Engineers Comments Regarding Surface Water Drainage

Application Reference:	A/20/26/DOC	Reviewer Reference:	ADC/EXT5/AF
Planning Officer:	Hannah Kersley	Date of Review:	17/04/2026
Site Name:	Land North of Water Lane Angmering BN16 4EJ		
Application Description:	Approval of details reserved by condition under A/248/21/PL relating to condition 29 -As Built Drainage.		
Assessment Number:	3

- 968_002_001-P04 - Drainage Verification Report: 'Phase 2.1 - Surface Water Drainage Verification Report' Revision P04 dated 07/04/2026.

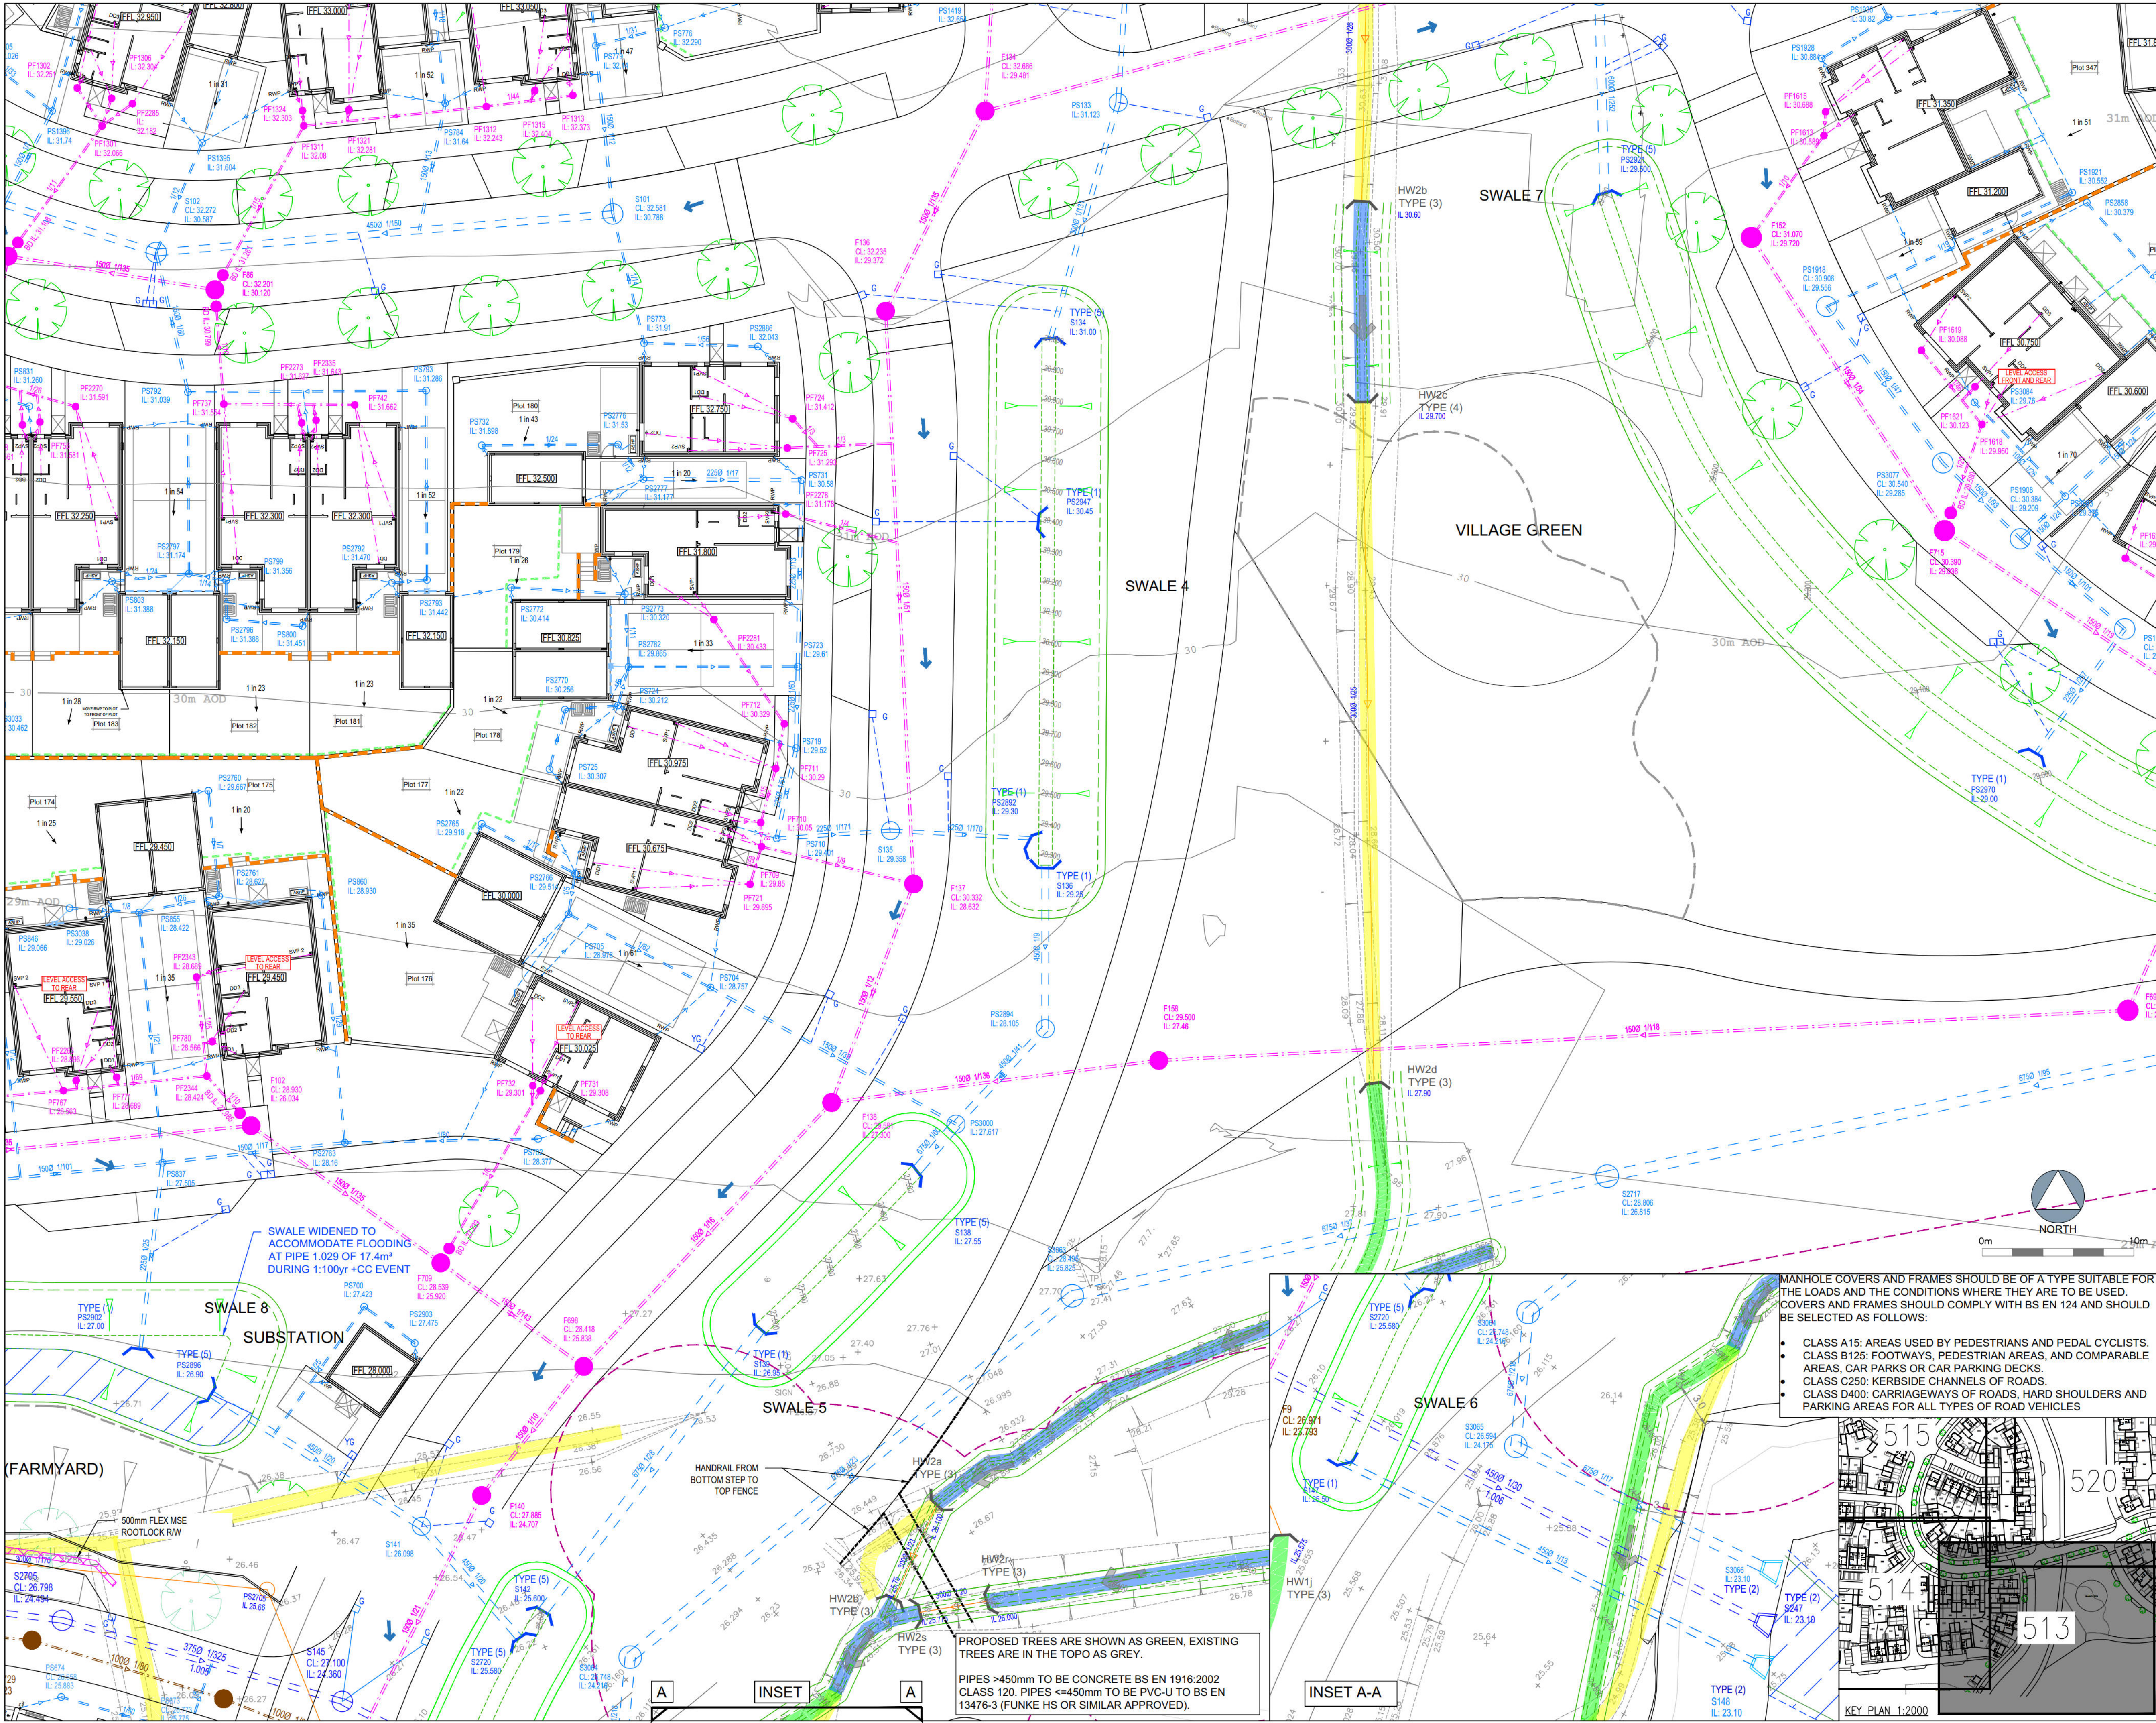
8.	S101 has an IL deviation of 344mm. Confirmation of no adverse effect on the functioning of the system is needed to support this change.	S101 is at the head of the drainage run. The diameter of the outgoing pipe is 450mm and its constructed fall gradient is 1/181 (refer to As Built Drainage Variations - Variation 6, paragraph 2.22), therefore there are no adverse effects on the drainage system.	Comment closed.
